Your ref:  
Our ref: 22/00055/F  
Please ask for: Miss Sandra Homcenko  
Direct dial: 01553 616824  
E-mail: borough.planning@west-norfolk.gov.uk

Details: **Retrospective application for Change of Use of existing kennels for breeding of dogs at Peace Haven Fen Road Wiggenhall St Mary Magdalen King's Lynn Norfolk**

Drawing number : 2118.01
rev : -

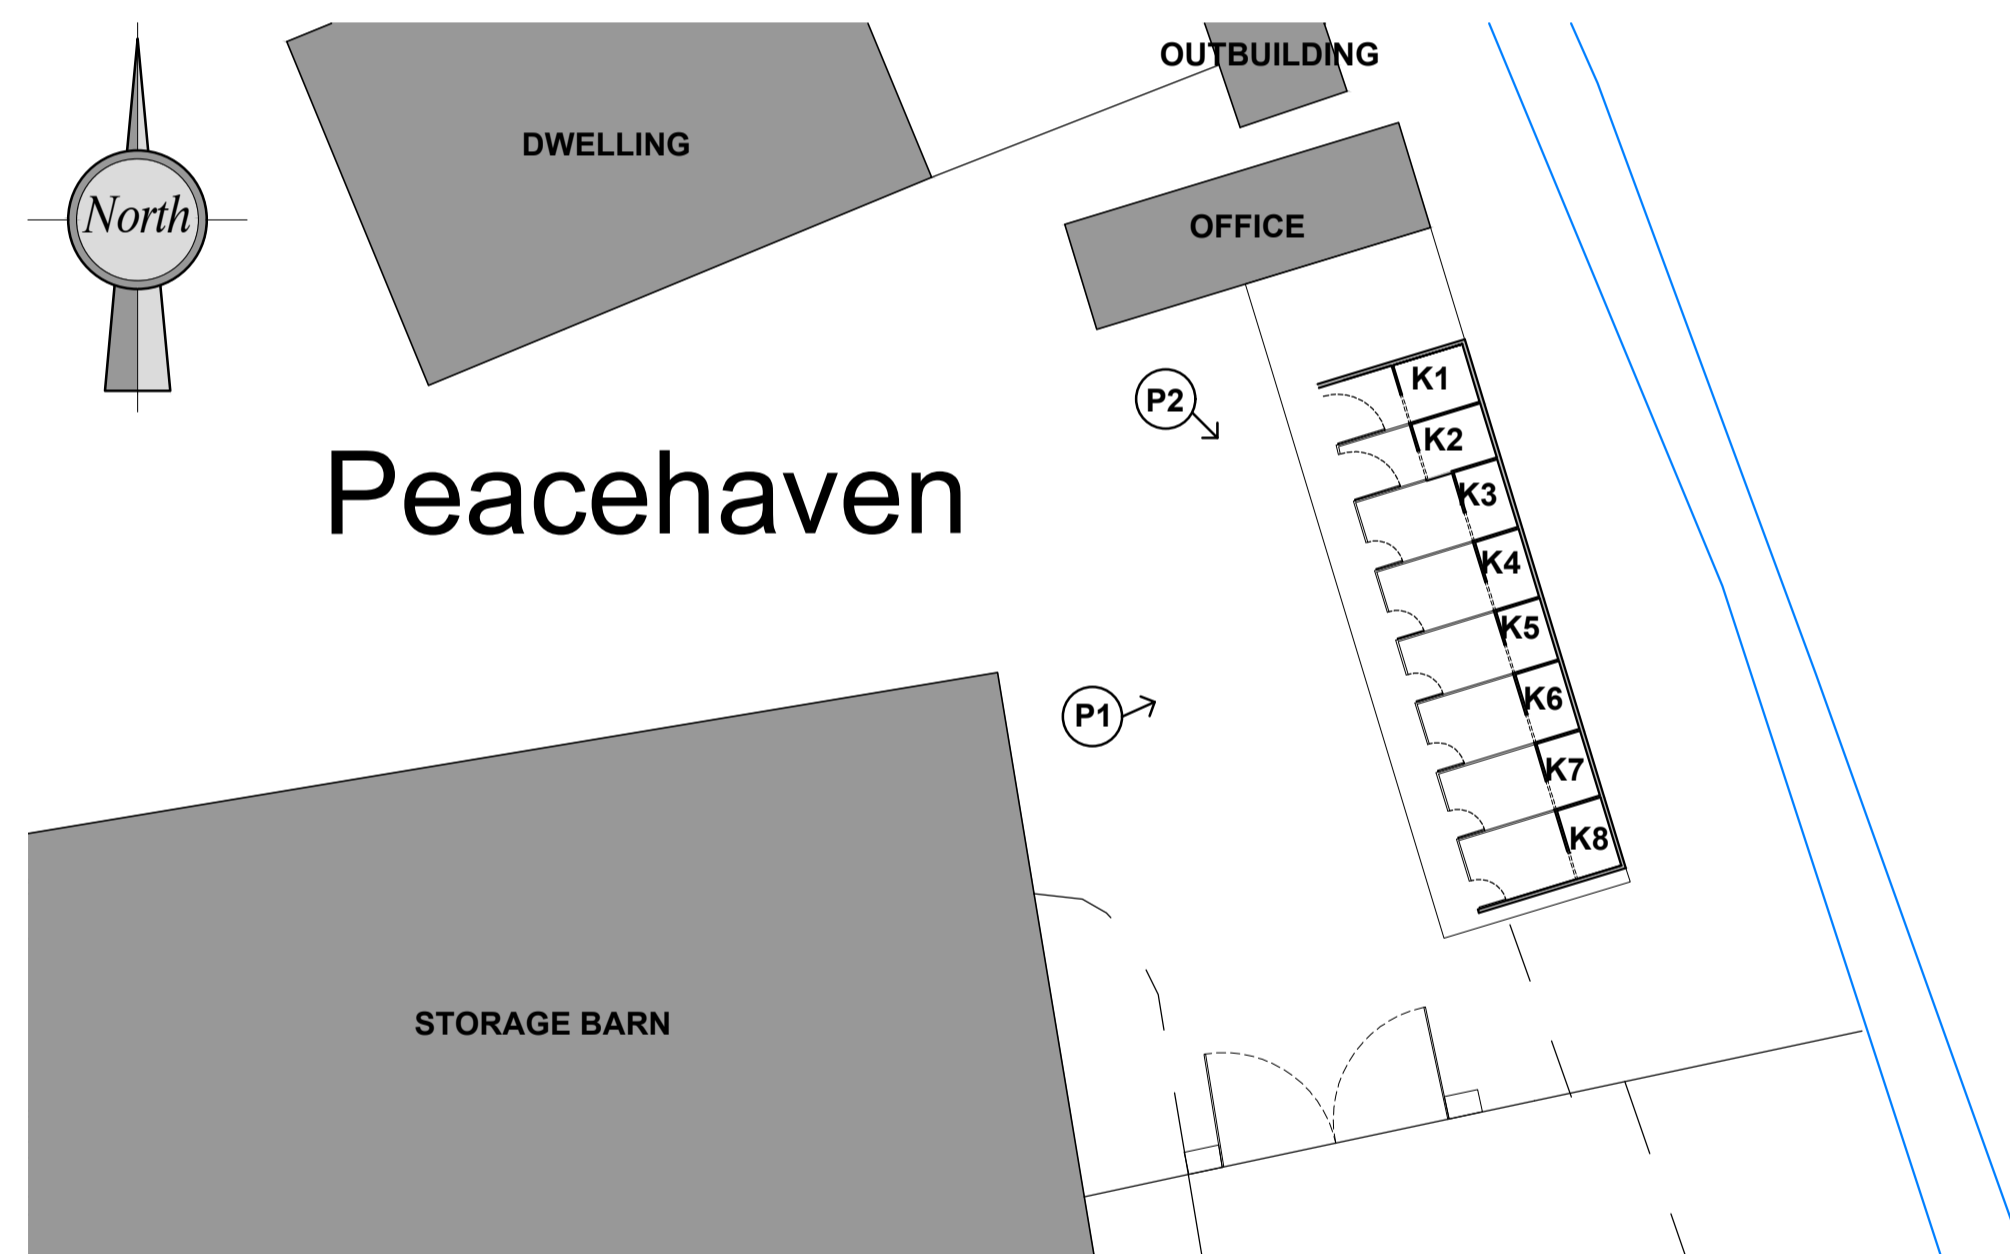
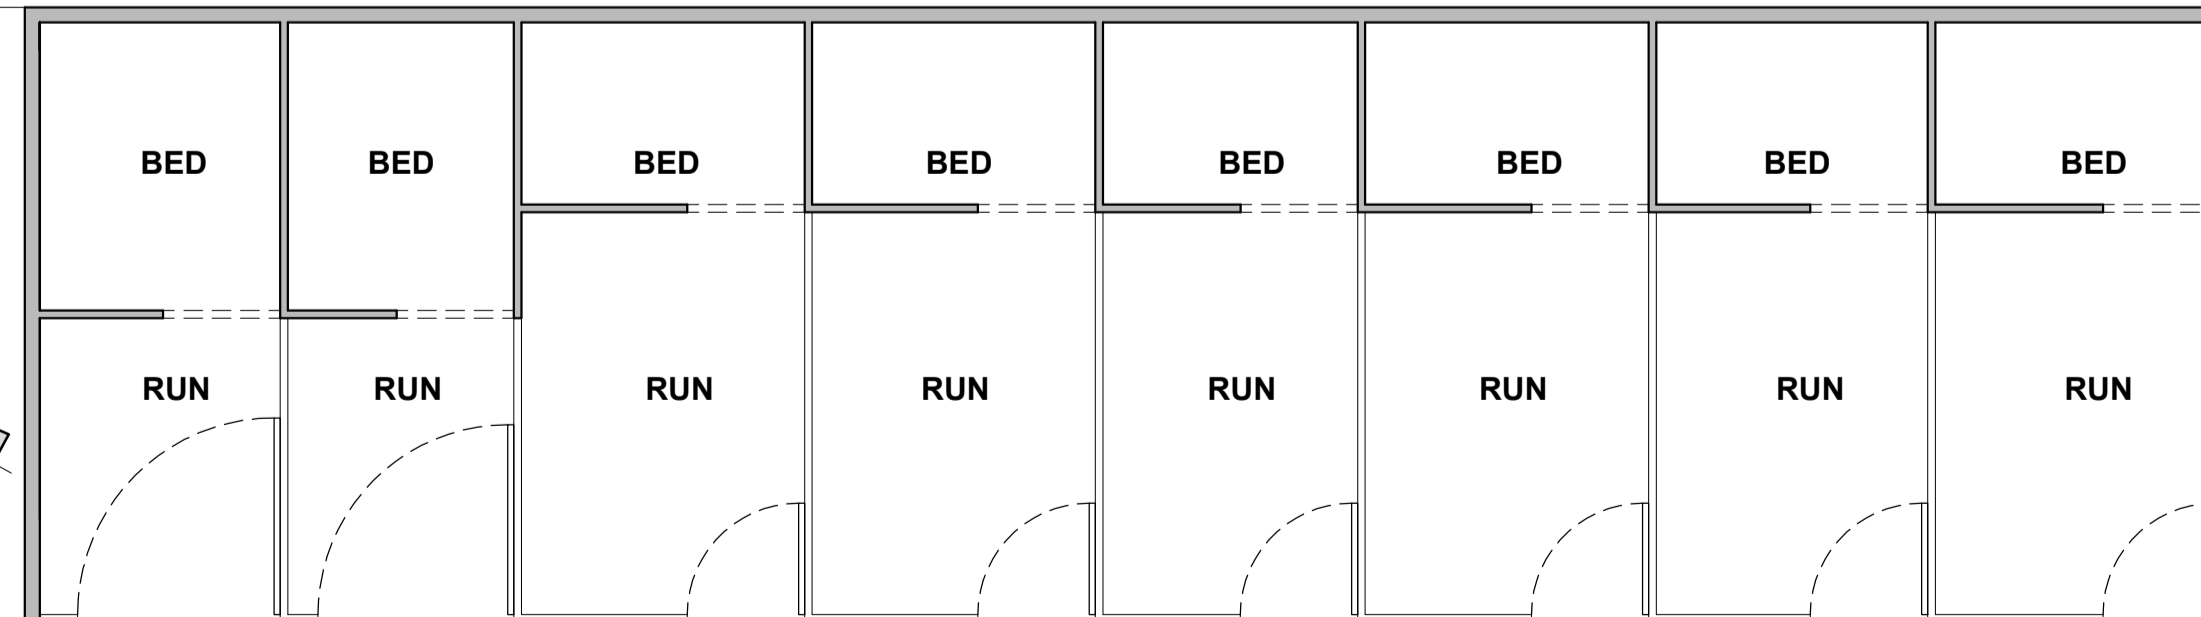
1. As this is a retrospective application, please provide plans showing what building looked like month ago before works commenced. If there were no changes made to the building please call your plan as existing and proposed.
2. For applications for the construction of kennels, in an area at risk to flooding, the Environment Agency ask for a statement to include the following information to be submitted to the Local Planning Authority.
  1. Confirmation that the applicant is aware that the area is at risk of flooding
  2. Where will the dogs be evacuated to in an emergency
  3. How will the dogs be evacuated in an emergency
  4. That the applicant is aware of the flood warnings available
